<b>Consultation Response from KC, Lead Local Flood Authority</b>
<b>2025/90517 land off, Forge Lane, Thornhill Lees, Dewsbury, WF12</b>
<b>Outline application, including the consideration of access and layout, for two commercial units (use class B2 and/or B8) and associated works</b>
<b>Date Responded: 24<sup>th</sup> February 2026 Responding Officer: Paul Farndale Responding Ref:</b>

1907

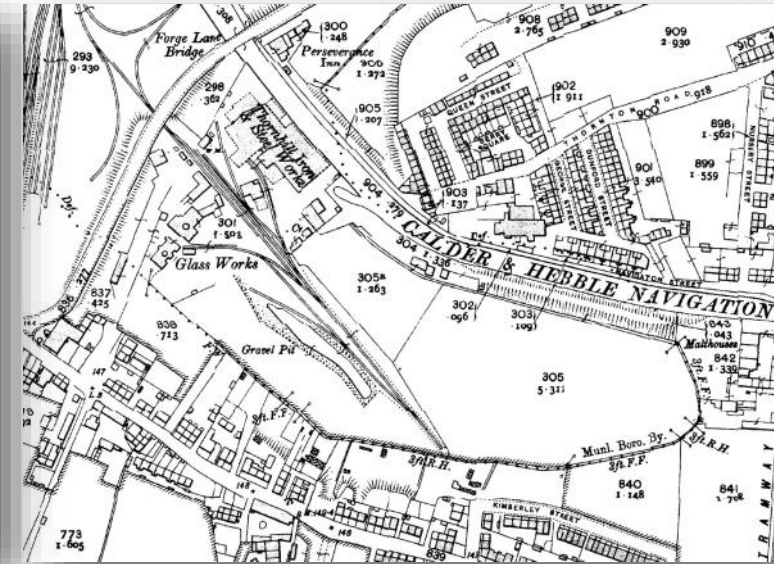
Using the word 'around' the site deliberately, please note the 1907 OS Map. This shows railway lines on site. The modern overlay from our database of watercourses and outfalls (blue lines), potentially match what could be open sections of watercourse coming in from the south (twin parallel lines) in two places on the historical map. The lines that continue around the perimeter of the site to the point where we have the syphon sewer.

Another watercourse line shows going straight to 'gravel' pit. This will be the forerunner to the modern pond.

1990 Forge Lane

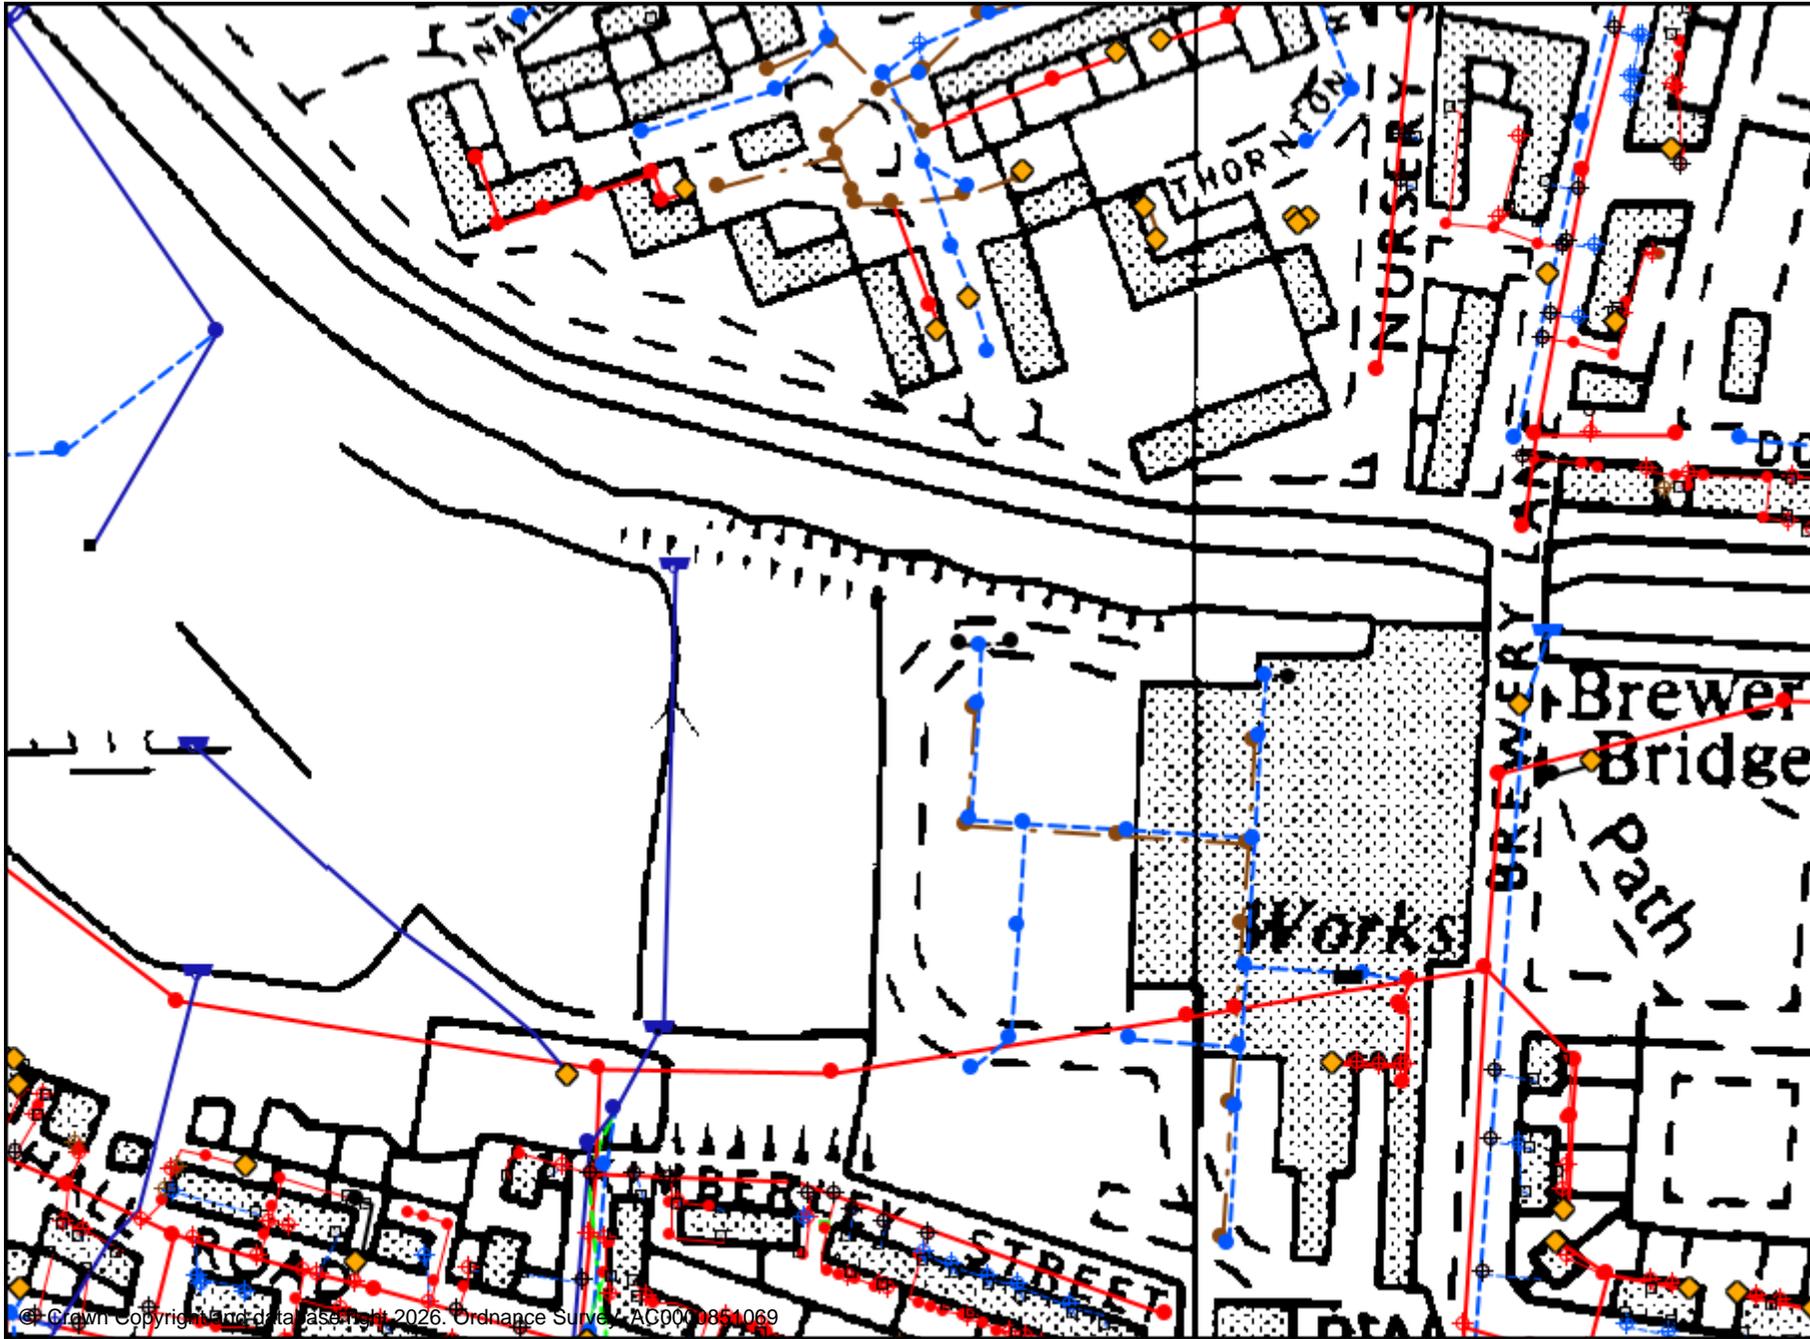
By 1990, the cricket ground has gone, and an open watercourse is shown right across it south to north and then moving west (not around the site).
